**Our Ref: LU/346/19/PL**  
**Your Ref:**

**Town & Country Planning Act 1990 (as amended)**  
**Town and Country Planning (Development Management Procedure) (England) Order 2015**  
**Application for Planning Permission**

**Development**      Extension to existing unit to provide covered storage .  
**Location**            Unit 10 Martello Enterprise Centre Courtwick Lane Wick

BLOCK PLAN 1/500

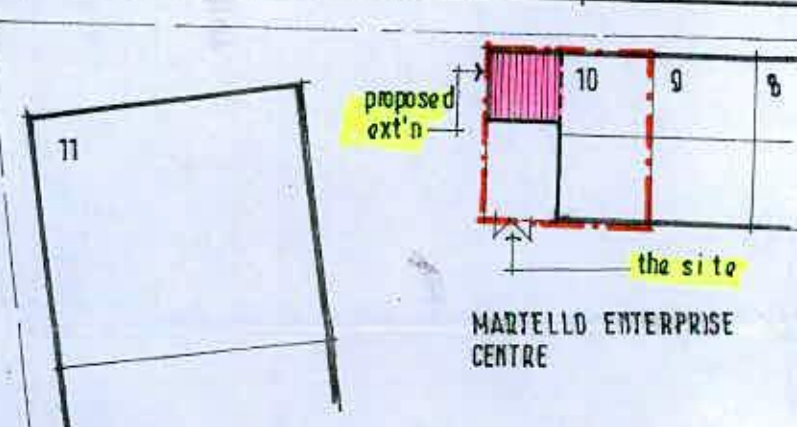
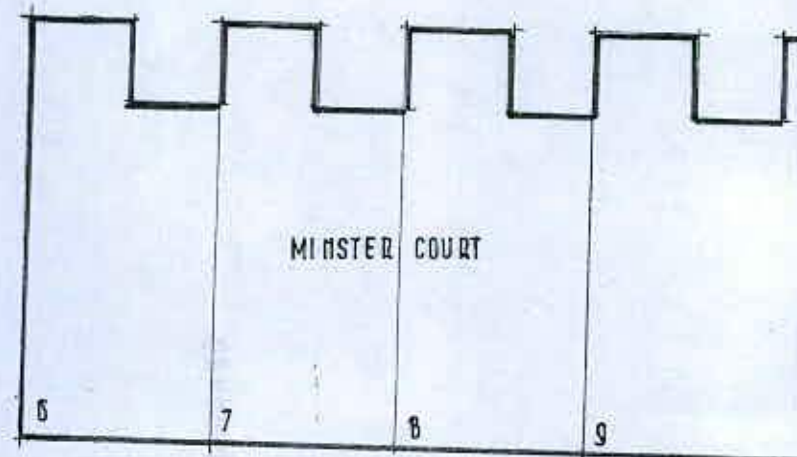
**Block Plan**

Please submit 1 electronic or 3 paper copies of an amended block/site plan at a scale of 1:500 or 1:200 showing the measurements to the boundaries.
